**KIRKLEES METROPOLITAN COUNCIL  
INVESTMENT & REGENERATION SERVICE**

**DELEGATED DECISION TO DETERMINE PLANNING APPLICATIONS**

Reference No:	<b>2025/62/92726/W</b>
Site Address:	Cote Farm, Penistone Road, Hade Edge, Holmfirth, HD9 2TA
Description:	Erection of two storey rear extension and single storey front extension with associated alterations
Recommending Officer:	Joanna Rednall

**DECISION – CONDITIONAL FULL PERMISSION**

scale date sheet size dwg. no.
1:100 07/2025 A2 25/1215/04d

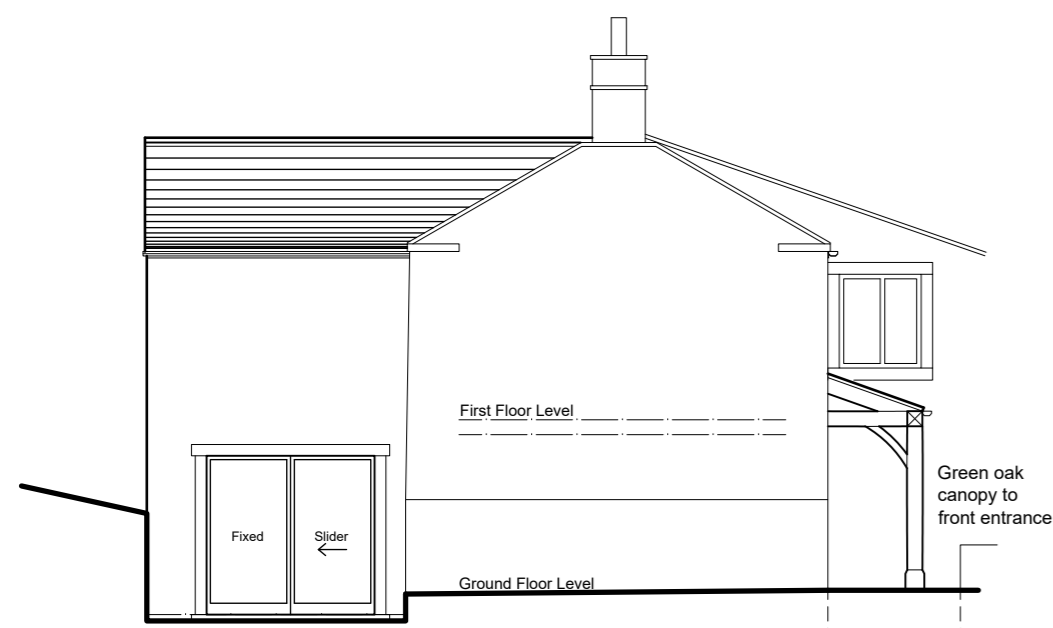
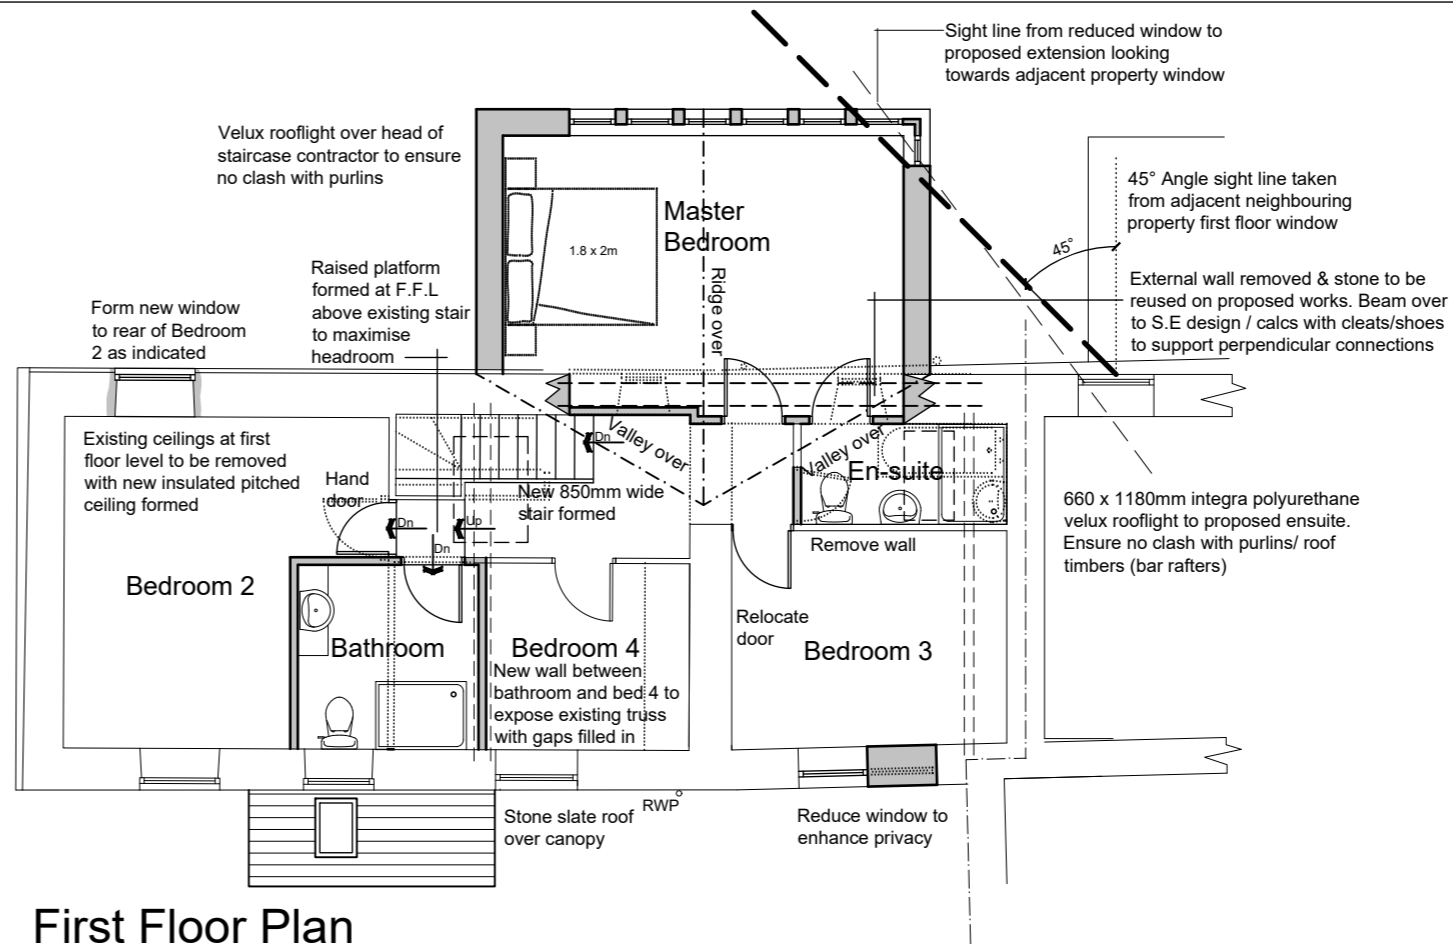
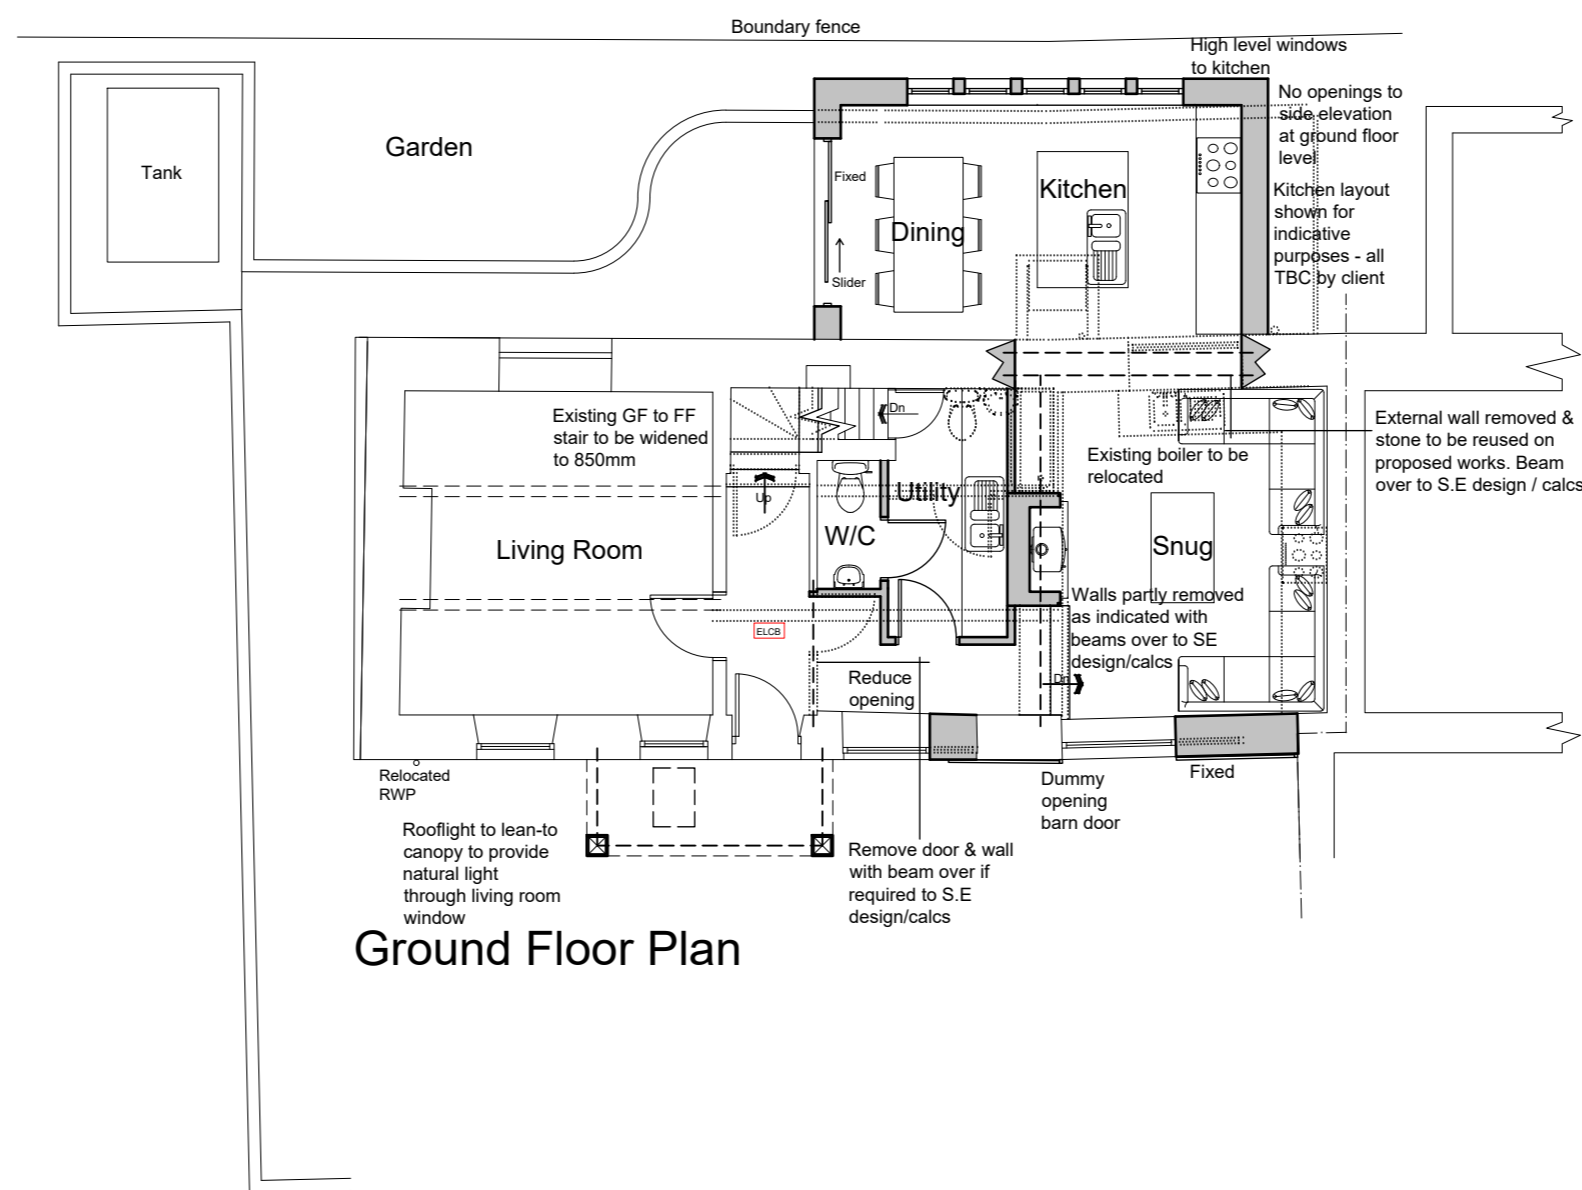
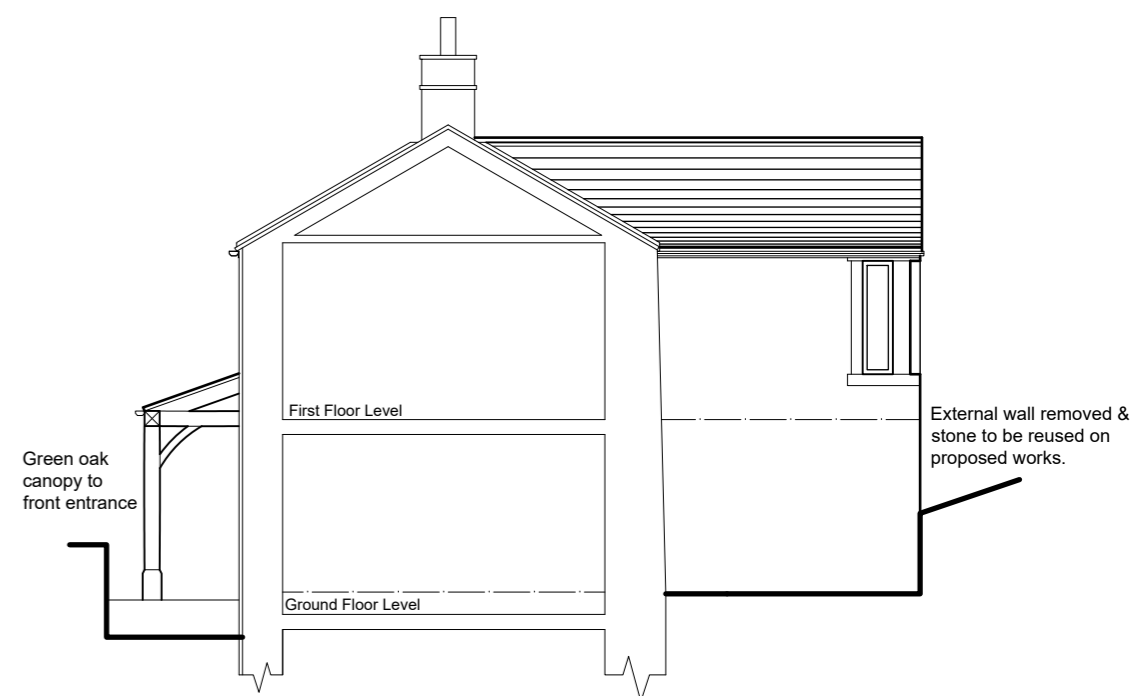
Concerns were raised with the applicant's agent regarding the potential impact of the proposal on the adjoining neighbour. Amended plans were received showing the extension repositioned further to the south-east, away from the neighbouring property, and the side-facing first-floor window reduced. These revisions were considered to address the concerns raised, and the proposal was progressed to determination on the basis of the amended plans.

The proposal has been amended during the course of the application to increase the separation from the shared boundary to approximately 1 metre, improving upon the original submission. Although this remains a shortfall against the SPD guidance, section 3 of this report establishes that the development would not result in material harm to the neighbouring dwelling. As the purpose of this design principle is to safeguard neighbouring residential amenity, officers consider that requiring the extension to be set in a further 0.5 metres would offer no meaningful design or amenity benefit.

The proposed front extension would not give rise to any additional impacts in terms of privacy or overlooking. The rear extension includes a narrow glazed window on the north-west elevation; however, this has been reduced in size compared to the original submission. In correspondence dated 10 November, the agent confirmed that the repositioning of the extension further from the boundary ensures there are no direct views into the neighbouring first-floor bedroom window. This relationship is clearly illustrated on the revised plans.

With regard to overshadowing and loss of light, officers raised concerns that the rear extension did not comply with the 45-degree rule used to assess overshadowing and outlook. In response, the extension has been repositioned approximately 1 metre away from the shared boundary. The amended plans now demonstrate compliance, showing a 45-degree line taken from the neighbouring property's first-floor window.
